OXFORDSHIRE COUNTY COUNCIL'S RESPONSE TO CONSULTATION ON THE FOLLOWING DEVELOPMENT PROPOSAL

Application no: 15/00760/F-2

Proposal: Development of a new Local Centre comprising a Convenience Store (use class A1), Retail Units (flexible use class A1/A3/A5), Pub (use class A4), Community Hall (use class D1), Nursery (use class D1), Commercial Units (flexible use class A2/B1/D1) with associated Access, Servicing, Landscaping and Parking with a total GEA of 3,617 sqm

Location: North And South Arcade At Bicester Eco Town Exemplar Site Charlotte Avenue Bicester

GROUND FLOOR PLAN

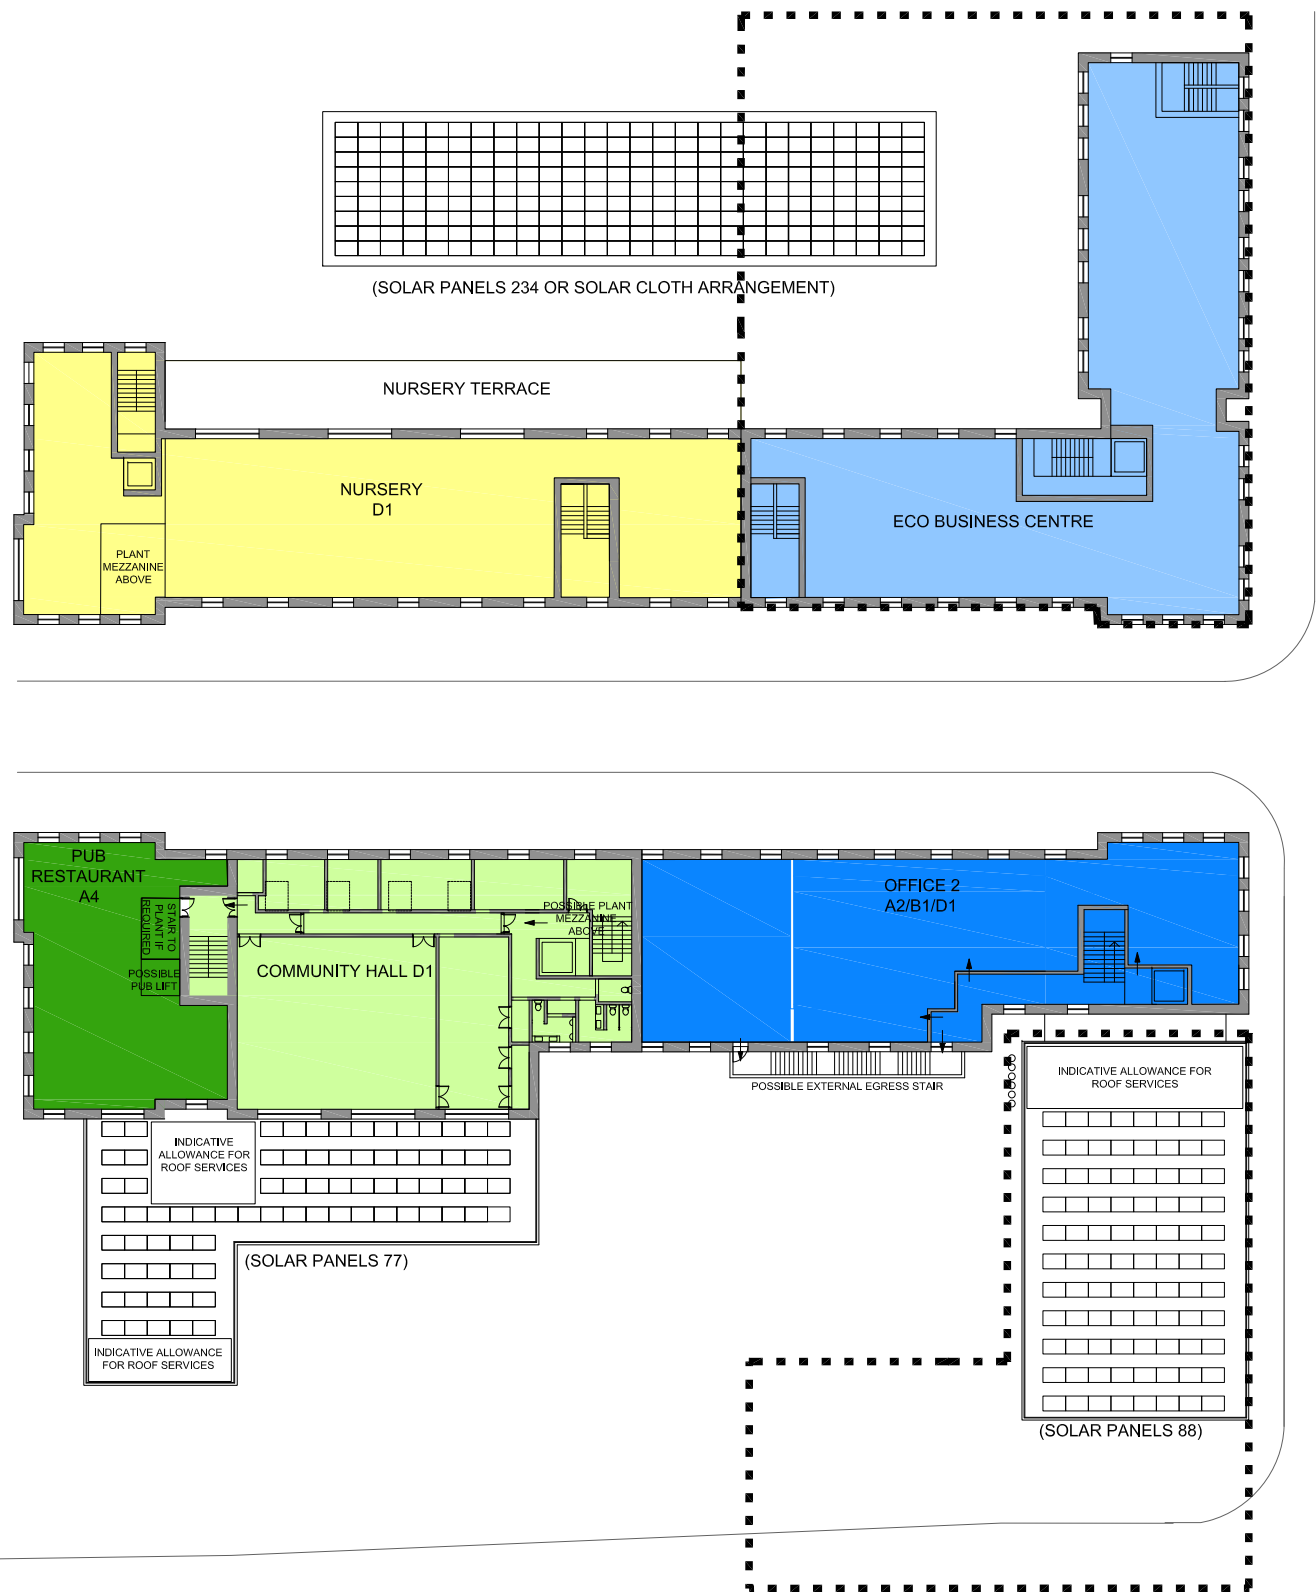
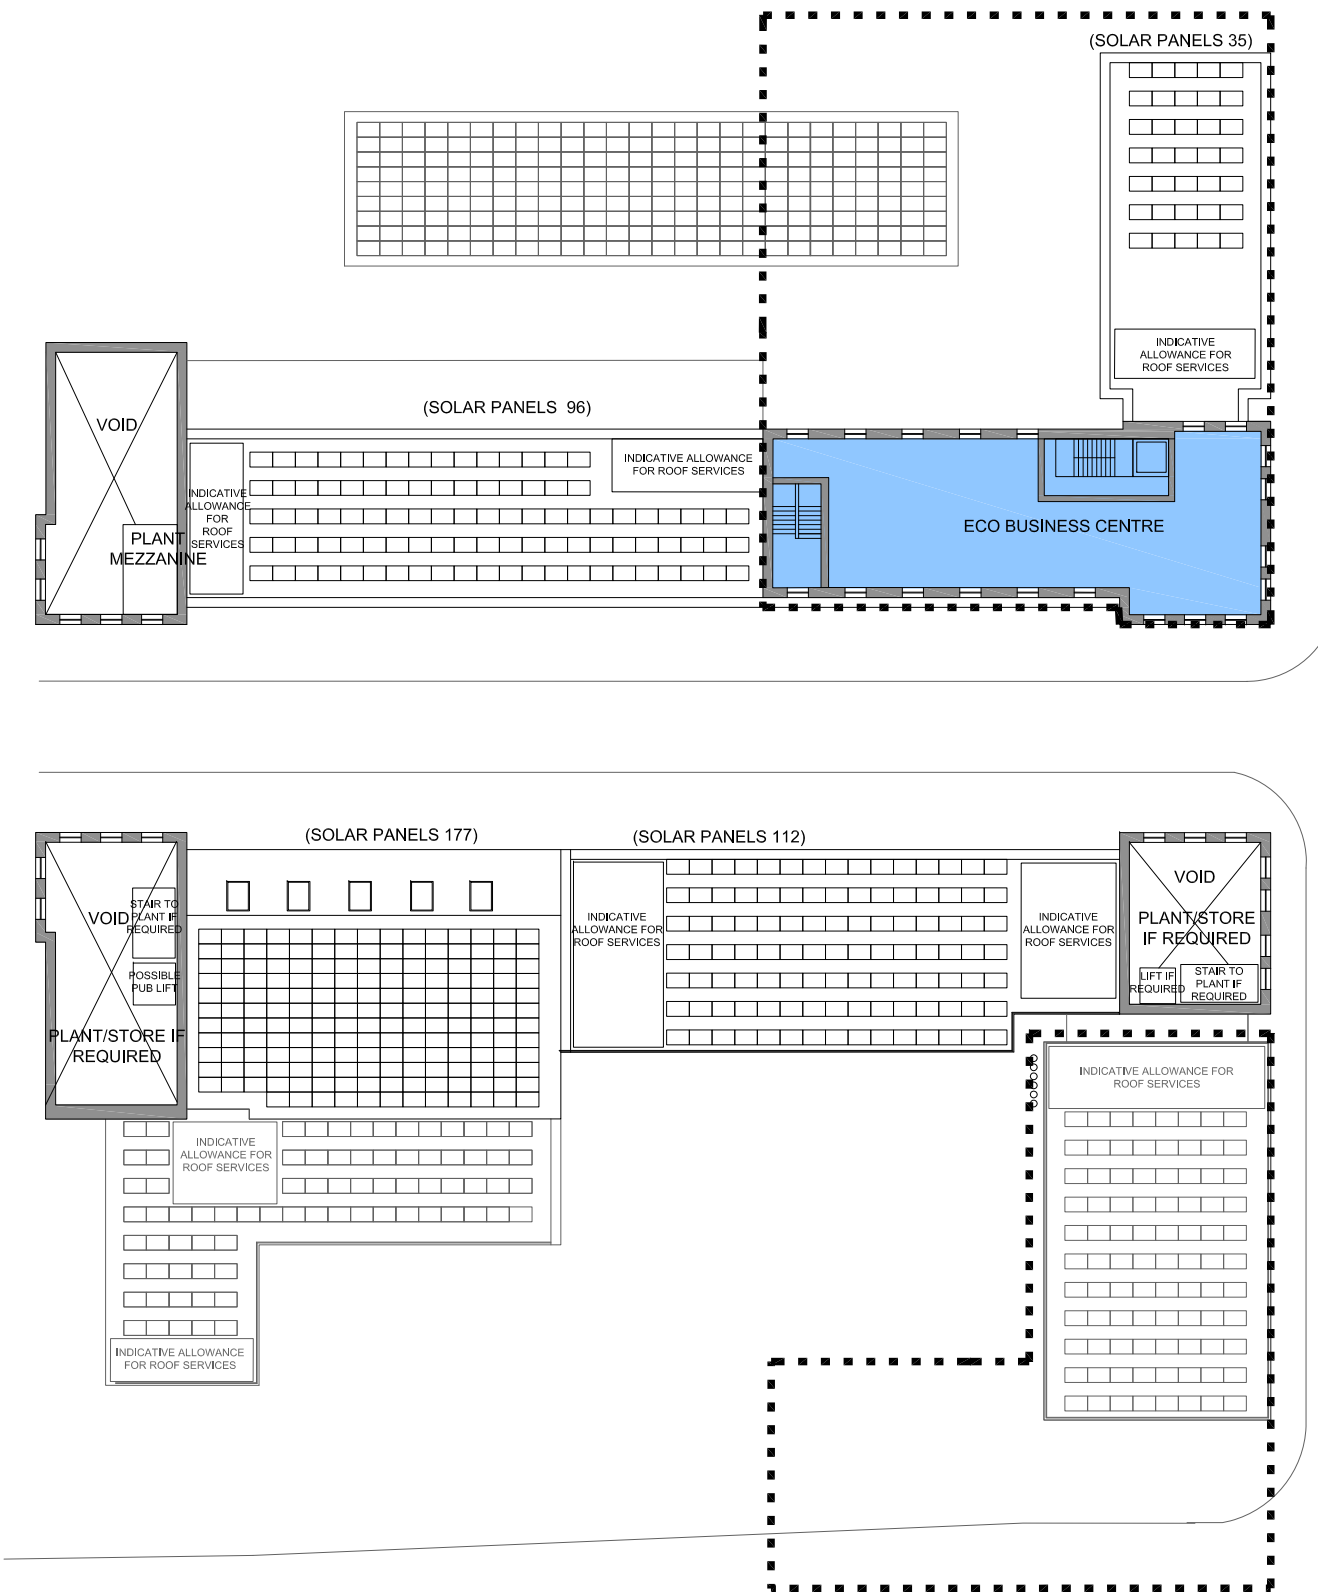
The proposed public car parking space (disabled space) outside the convenience store is too wide which doesn't leave much space for an adoptable footway immediately adjacent to it. The width of this space should be reduced to 3m width which should leave at least 2m for the footway adjacent to it.

The proposed street design would need to be the subject of a revision to the S38 agreement, which would require further technical audit. It would be helpful for the applicant to confirm the areas proposed to be offered for adoption at this time. The submitted drawings appear to indicate a colonnade on both sides – areas underneath this will not be adopted.
